Your Ref: OWPC14836
Our Ref: A/121/17/HH 21-06-2017
Please ask for:
Mrs A Gardner

Detached double garage & single storey extensions to existing garage.
Harcourt West Drive Angmering

Thank you for your internet representation made on 1st August 2017 which has been recorded as '**an objection**' with the comments as follows:

<table><tr><td>PROJECT HARDCOURT West Drive, Angmering Littlehampton. BN16 4JE</td><td rowspan="4"> 29 Breach Avenue, Southbourne, Emsworth, Hampshire. PO10 8NB T: 01243 697164 M: 07879471666 www.pdkconsulting.co.uk</td><td rowspan="4"> PDK Architecture and Surveying</td></tr><tr><td colspan="2">DRAWING PROPOSED SITE PLAN</td></tr></table>

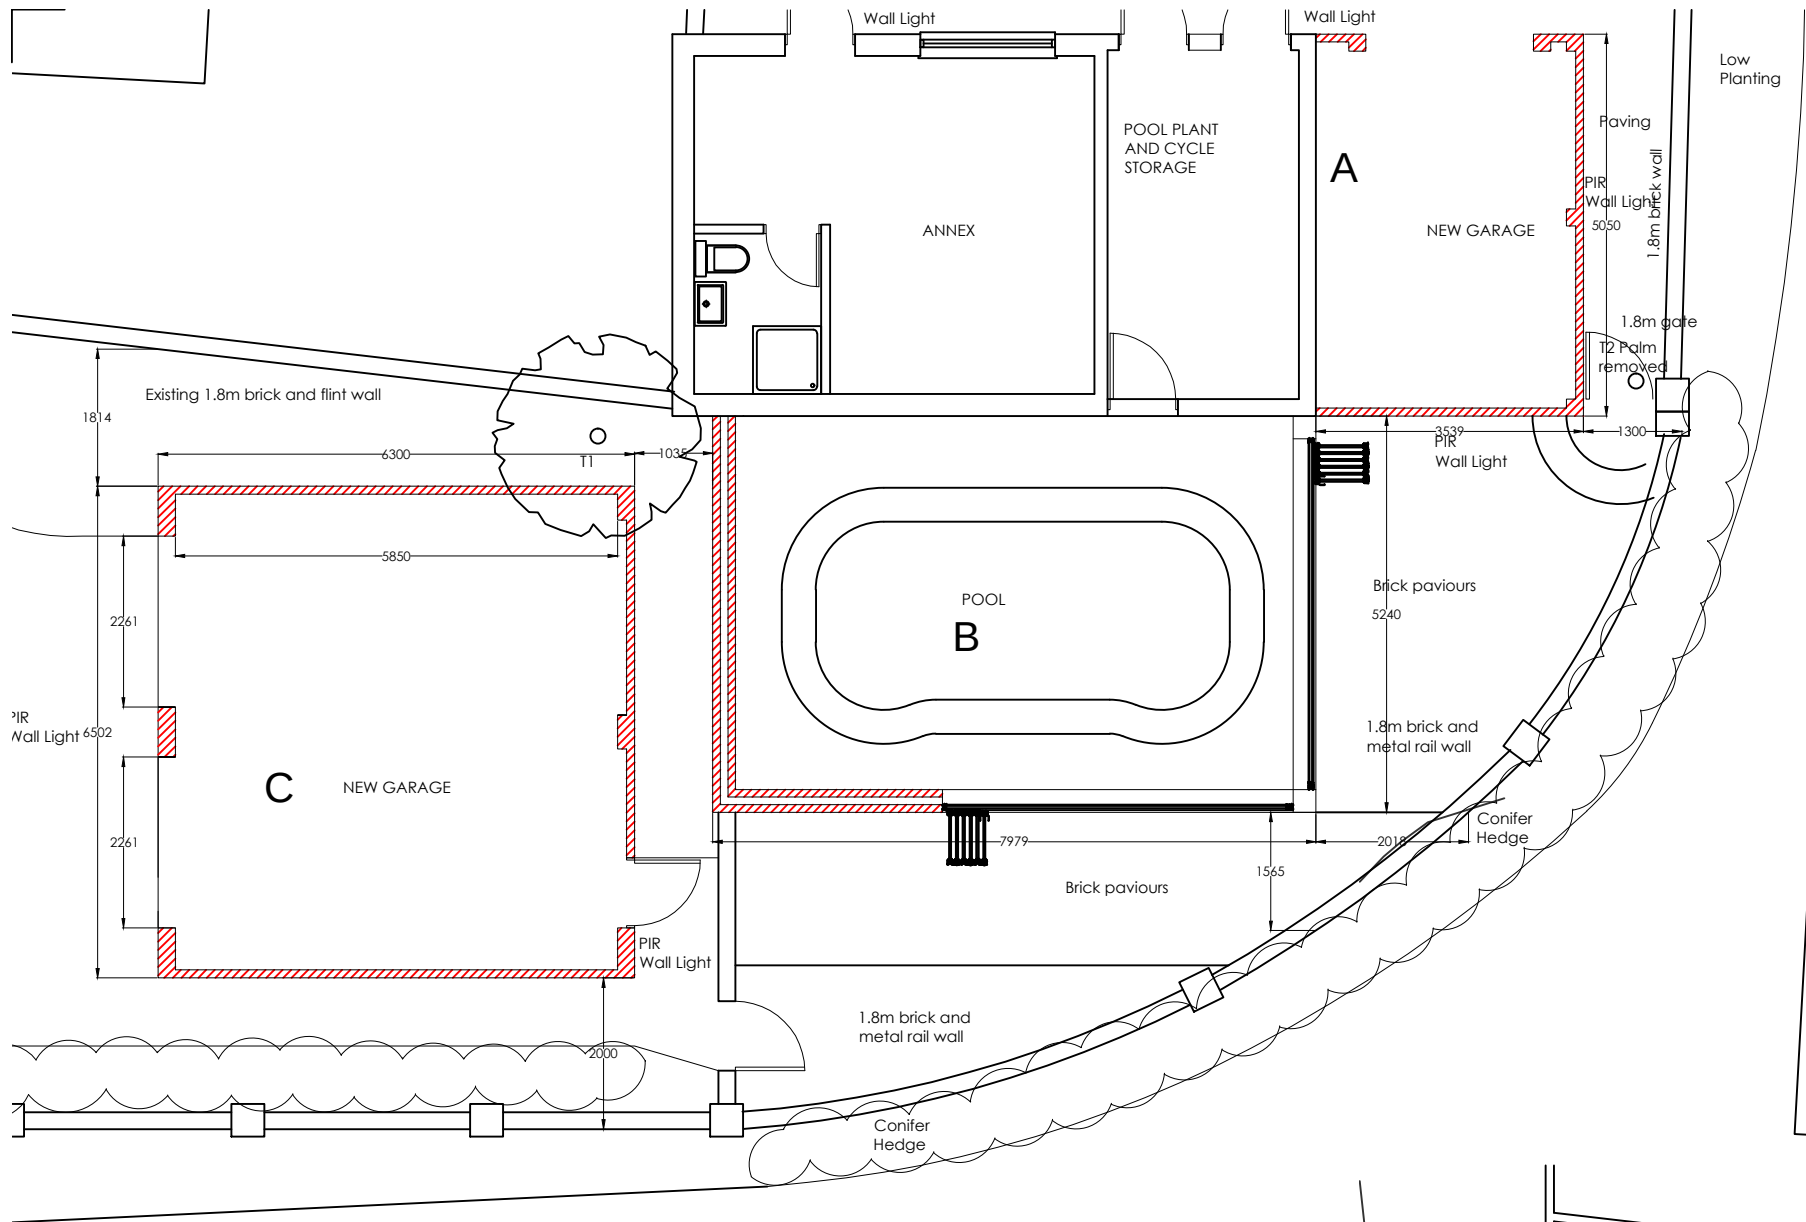
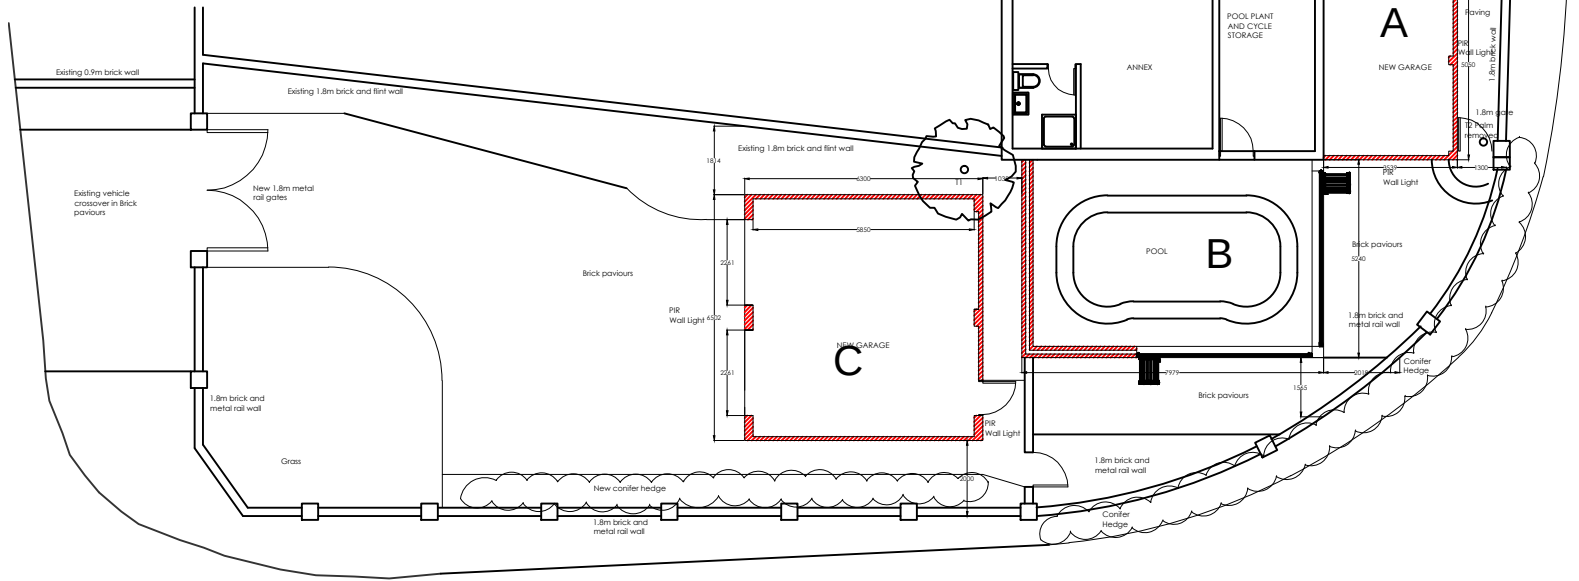
I strongly object to the petitioner being allowed to build a tall (the height is unknown and not stated in the plan) double garage and driveway which will completely obliterate the existing garden area that the neighbourhood has enjoyed for many years as a neatly kept green space. Well it was nicely landscaped up until the past year when it has been allowed to become a home for weeds. The homeowner already has parking and garage space, though has chosen to keep part of it as a 'grannie annex' and a pump room for his pool.

The garden area the applicant wants to build upon used to belong to my house and is right beside my property. This space has always been a garden and even when the previous owner tried to put a solid wall around it, approval was turned down because it was felt the wall was not in keeping with the area. Harcourt, the applicant's house, is around the corner and completely nonadjacent to the proposed garage and driveway. Will this end up looking like a used car lot plonked down beside West Drive, not 'belonging' to any house?

I suggest it will and thus will diminish the open, scenic character of the area; something I understand would be in contravention of the local plan. Construction of the double garage and long driveway will completely change the street scene of West Drive.

Speaking of floods, the garden area currently provides a crucial soakaway for all the rainwater that comes down off the slope of the New Road area on to West Drive. Building over this space will surely make matters worse. My house insurance company just raised my premiums telling me it's due to "surface water flooding" on West Drive. By the way, my house is about two metres higher than West Drive - something I pointed out to the insurance company to no avail.

The garage will be too near the foundations of my house; giving me cause to worry about the stability of my dwelling. The garage will also plunge an area of my back garden into permanent deep shade.

The exit from the driveway which the application has running the length of the garden will be awkward, not to mention unsafe. There is a lot of vehicular traffic to and from the Golf Club using West Drive plus cars coming down to West Drive from New Road. And let us recall that New Road and West Drive as it runs south, is a public footpath which is constantly used by people on foot going to and from Out of Bounds, the health club and the public golf course, as well as school children walking to the local school.
